Major Projects Assessment,
Department of Planning and Infrastructure
GPO box 39
Sydney 2001
Attention: Director, Infrastructure Projects
Reference: NWRL EIS2 Objections
Application Number: SSI-5414

This submission is to voice our concerns and the lack of support to the planned changes to the traffic flow in Robert Road by the NWRL as detailed in EIS2 which, in our opinion does little to satisfy the concerns of the majority of residents in Robert Road and the community titled estates that run off Robert Road. We understand that you will be receiving a number of submissions, some echoing our concerns, and we sincerely hope that you will give all due considerations to those submissions.

Figure 6.12 Cherrybrook Station - Indicative vehicle and pedestrian movements

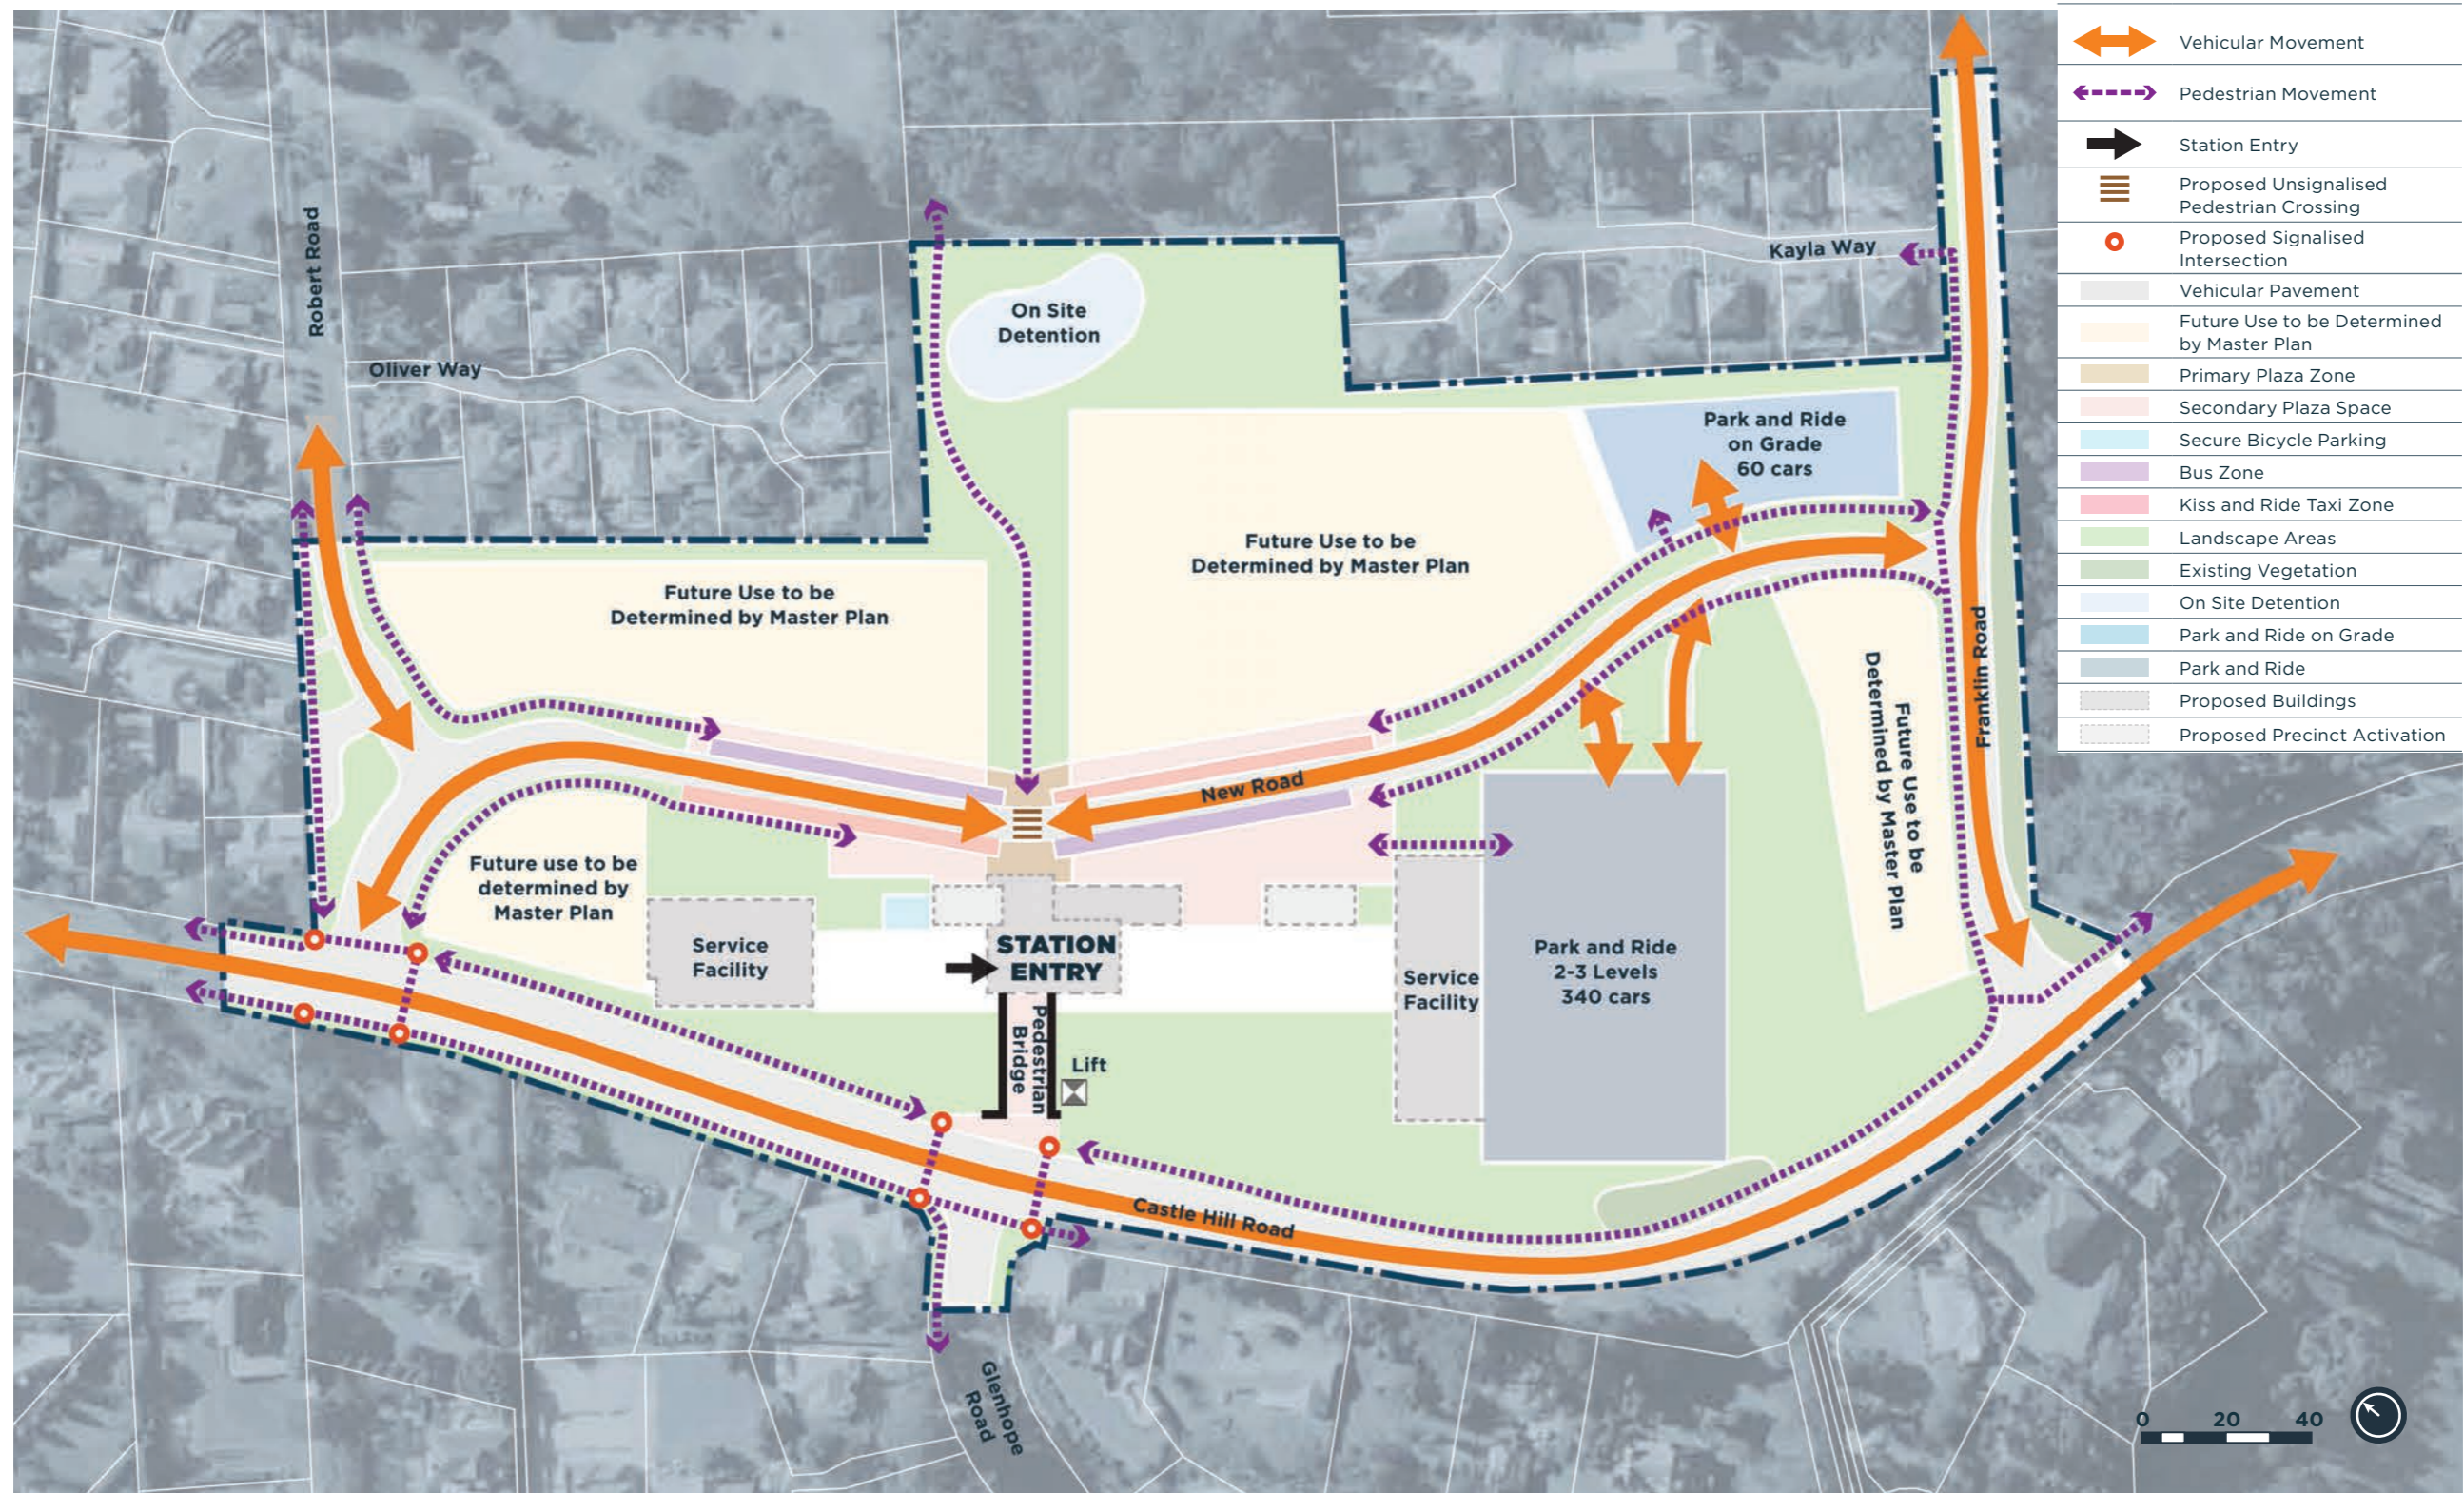
There is a proposal that Robert Road will be used as a major feeder road into Cherrybrook station, requiring two way bus accesses to the station precinct. This suggestion is regarded as a complete

lack of knowledge as to the current traffic movements in Robert road, and to accept Robert Road as a feeder road in any capacity would endanger to lives of residents of Oliver Way and Robert Road. The traffic movements noted in EIS 2 are not correct.

With the NWRL proposal of running buses along Robert Road in both directions, the danger would be greatly increased and intolerable.

As a result, to avoid any buses being caught in this anticipated traffic, the NWRL have proposed buses to run left off County Drive into John Road and then right into Robert Road.

We are totally against this proposal based upon the aforementioned facts.

There should be no access into Robert Road from the Western end of the Cherrybrook Railway Station complex, or from Castle Hill Road, and to improve safety, Robert Road should be converted into a Cul-de-sac at Castle Hill Road. Robert Road is not designated as a LOCAL road (as referred by Council) by any standards. **See report By INCO Traffic management on page 2.**
